Recommendation Report for Planning Permission for Works or Extension to a Dwelling

REF NO: M/105/20/HH

LOCATION: 22 Tudor Close
Middleton-On-Sea
PO22 6DN

PROPOSAL: Removal of existing roof structure, new first floor accommodation and pitched roof above and replacement rear single storey extension.

PROPOSED ROOF PLAN

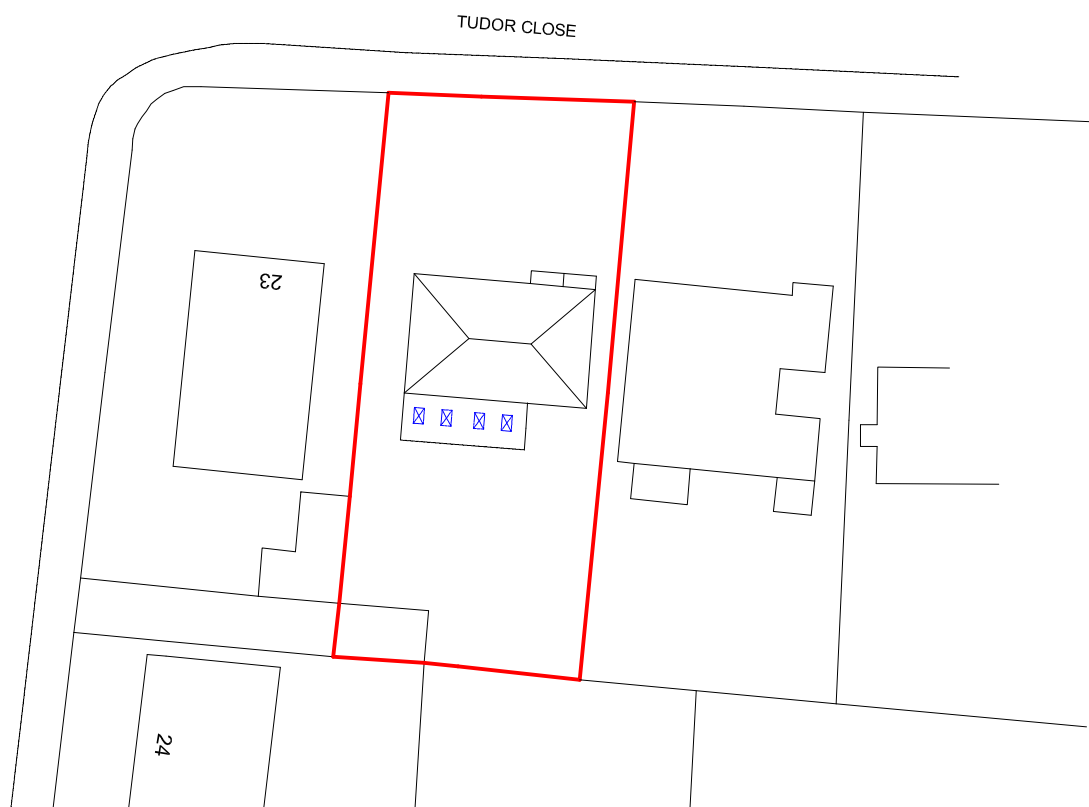
DESCRIPTION OF APPLICATION The application seeks to remove the existing roof structure, and replace with a new first floor with a pitched roof above, and a replacement single storey rear extension. The maximum roof height will increase from 6.45m to 9.1m.

The proposed development seeks to remove the roof structure of the existing host dwelling, and replace with a full first floor and new roof structure thereby increasing the height of the existing dwelling by over 2m.

PROPOSED GROUND FLOOR PLAN

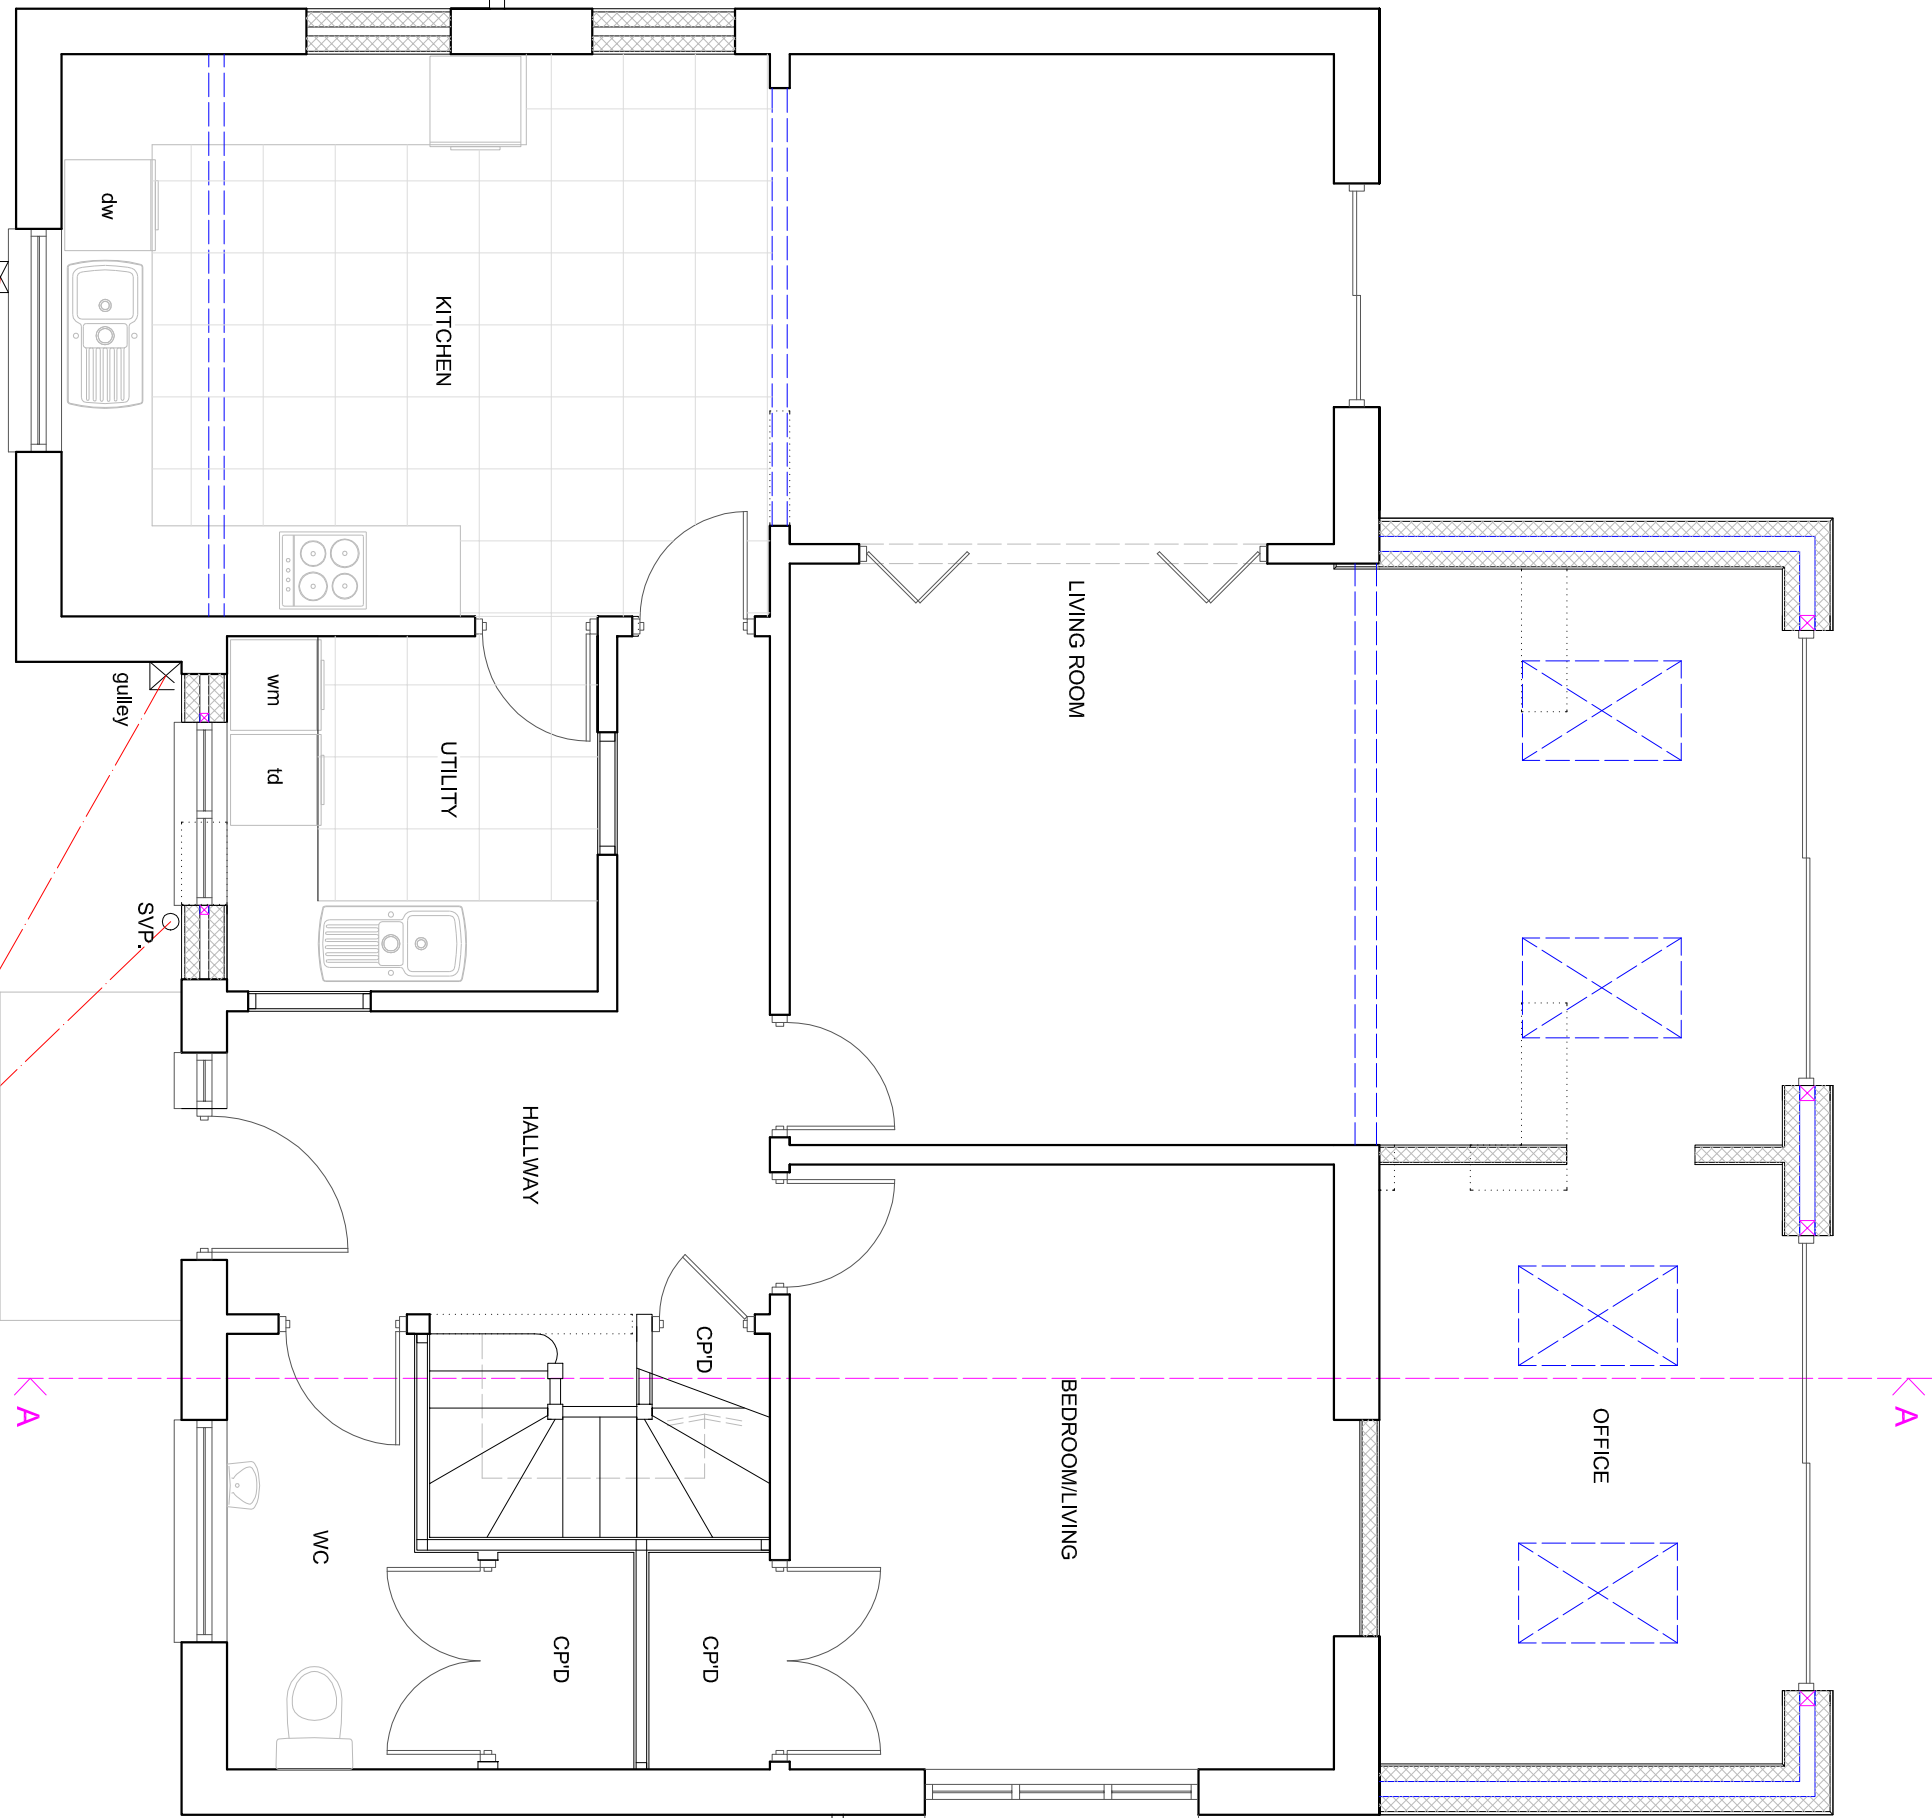
The proposed single storey rear extension is not considered to result in a harmful impact upon the host dwelling or that of the locality. This is due to the scale of the proposal and its siting meaning that there are no views of the proposal from the street scene.

Whilst the proposed development does result in a large increase in bulk when close to its side boundaries, the footprint of these proposed extensions broadly align with those of the neighbouring dwellings, to create a reasonably standard side-to-side relationship.

PROPOSED FIRST FLOOR PLAN

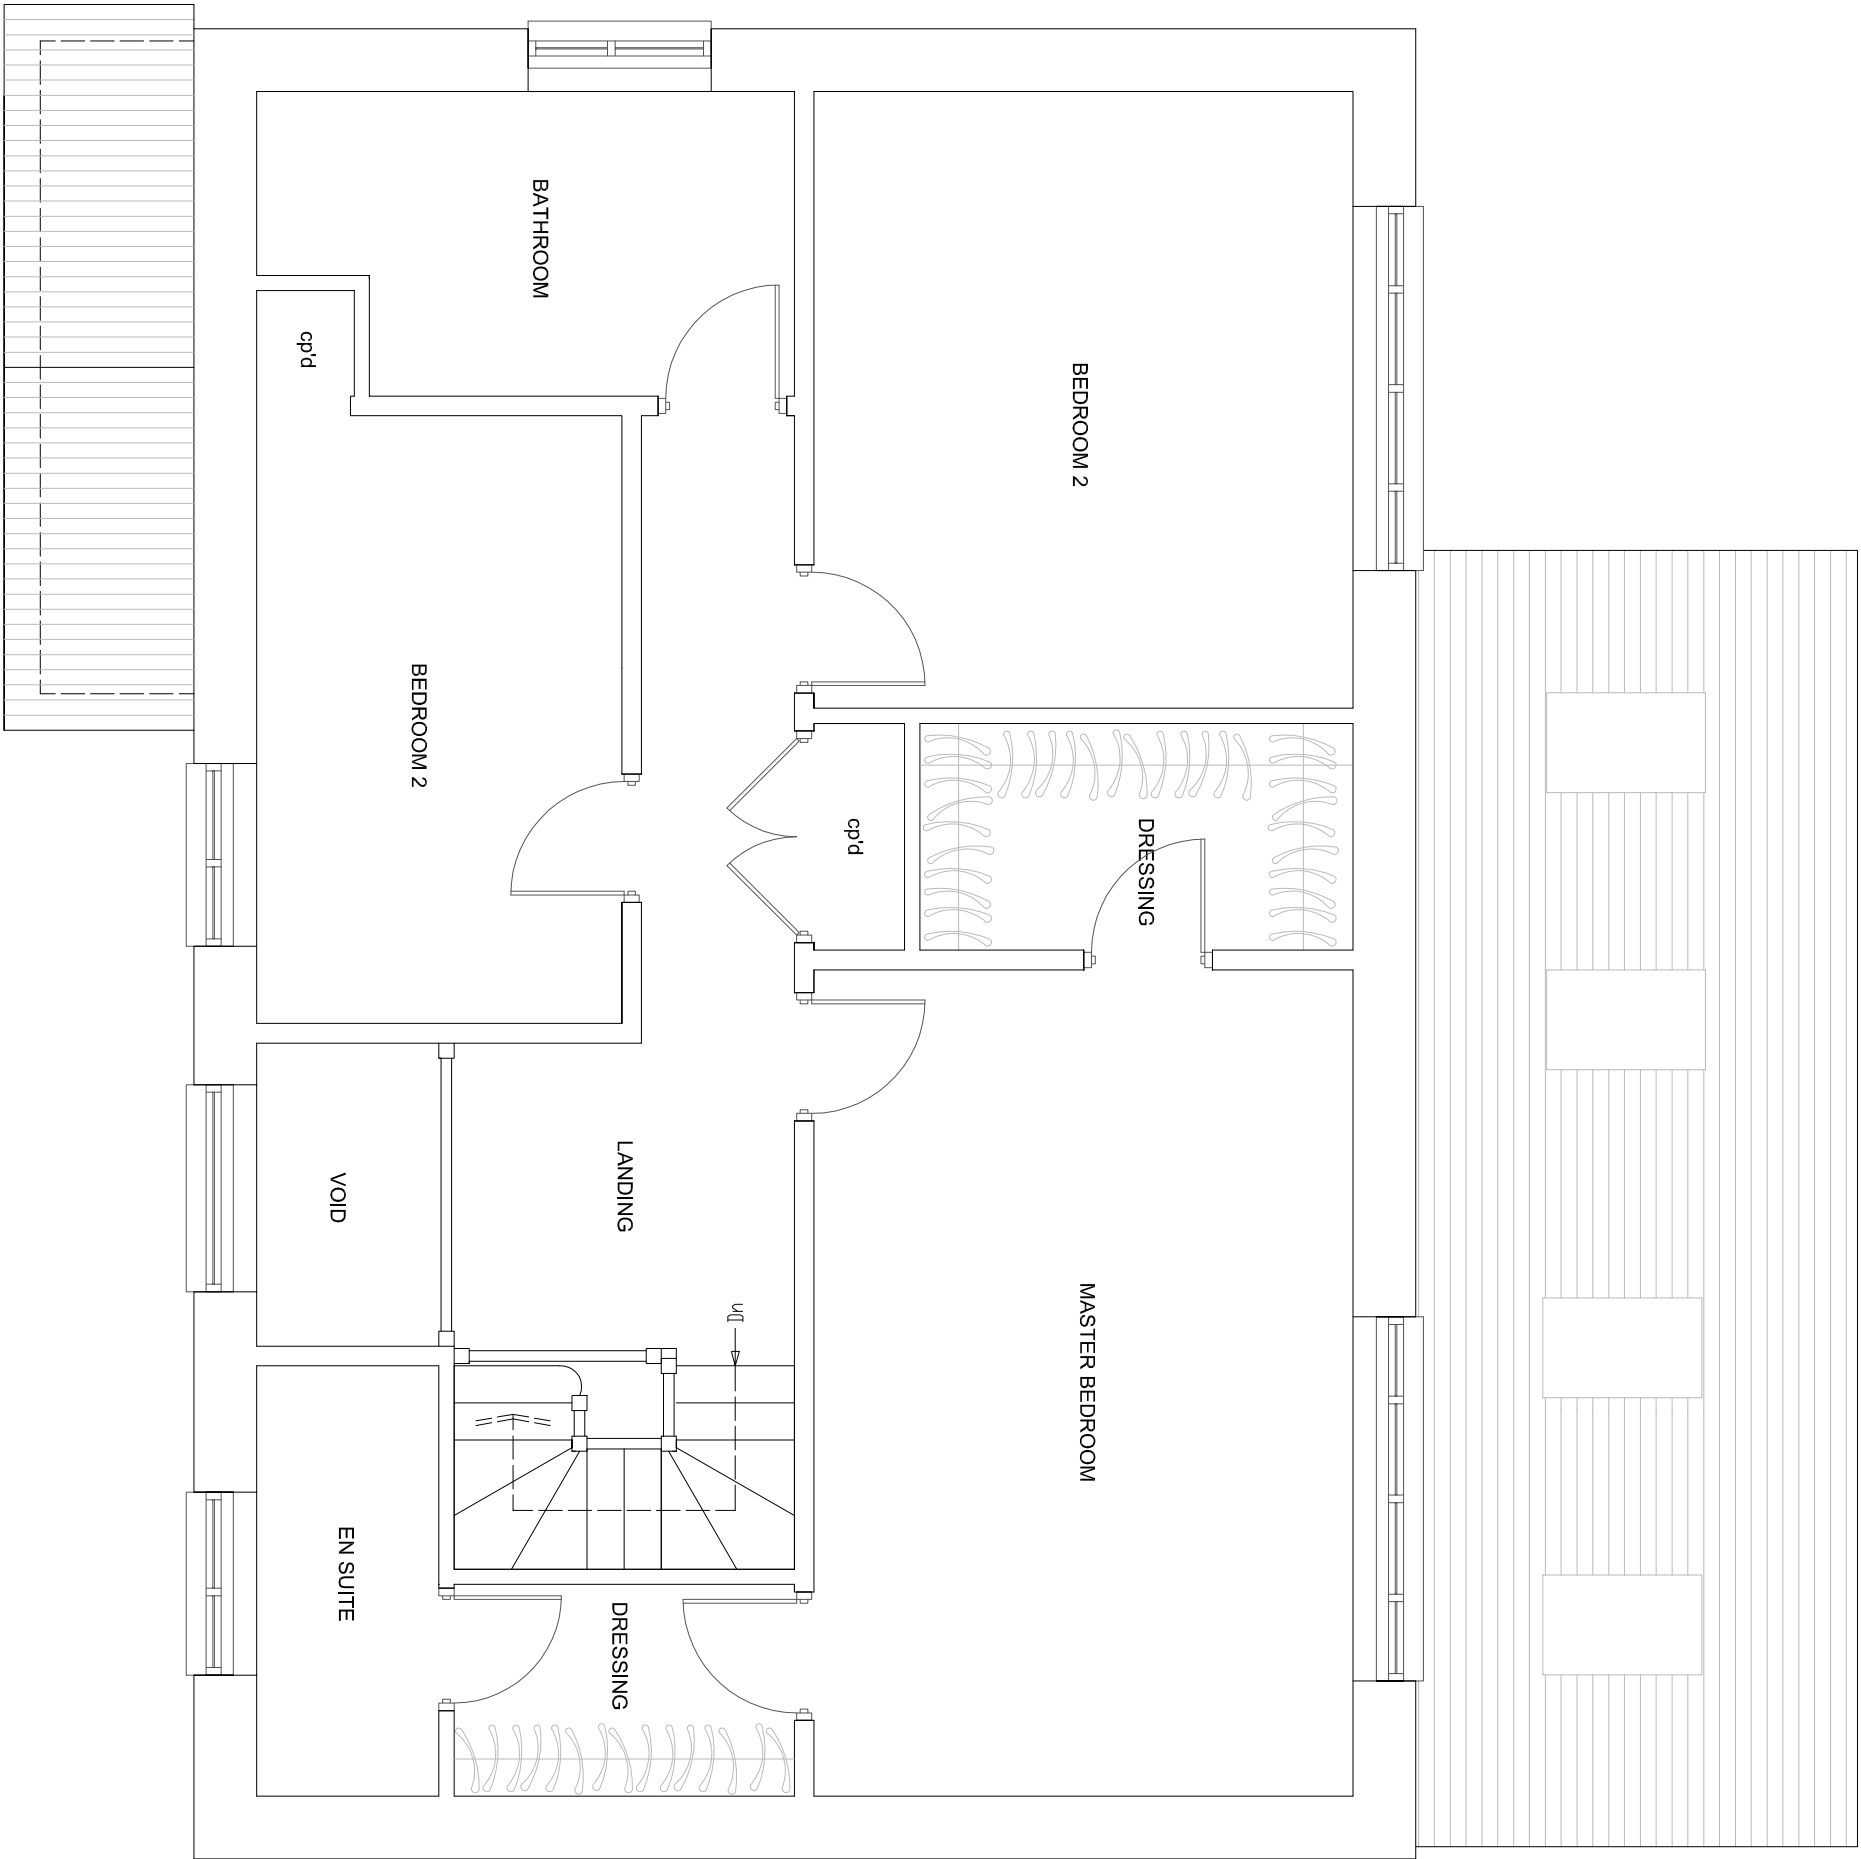
The proposed development will not result in any unacceptable harmful loss of privacy to the occupiers of nearby dwellings, in that whilst there are proposed first floor windows, they are to the front, and the rear of the host dwelling. This means that the windows are considered to provide views within the application site only with, acceptable oblique views of neighbouring private amenity areas.
